Re. Building Permit

Ref 10 STRATTON
K. Brown

CBL 448-040

Project #3

Project #3

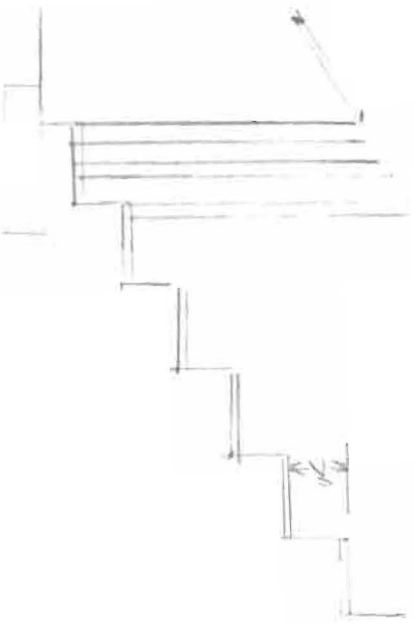
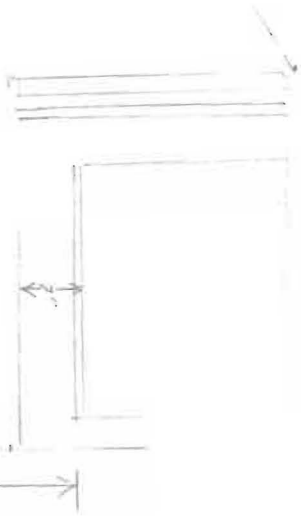
As sketched on Plot Plan Existing steps don't meet
Required Boca Code and go within 2' of Property line

I planned on turning steps 90° to meet set back
and BOCA Code. this Increased three Foot print.

Which conflicts with Condition of Approval #31 on
Permit # 00138

Please Advise after reviewed.

OK under
Section 14-440
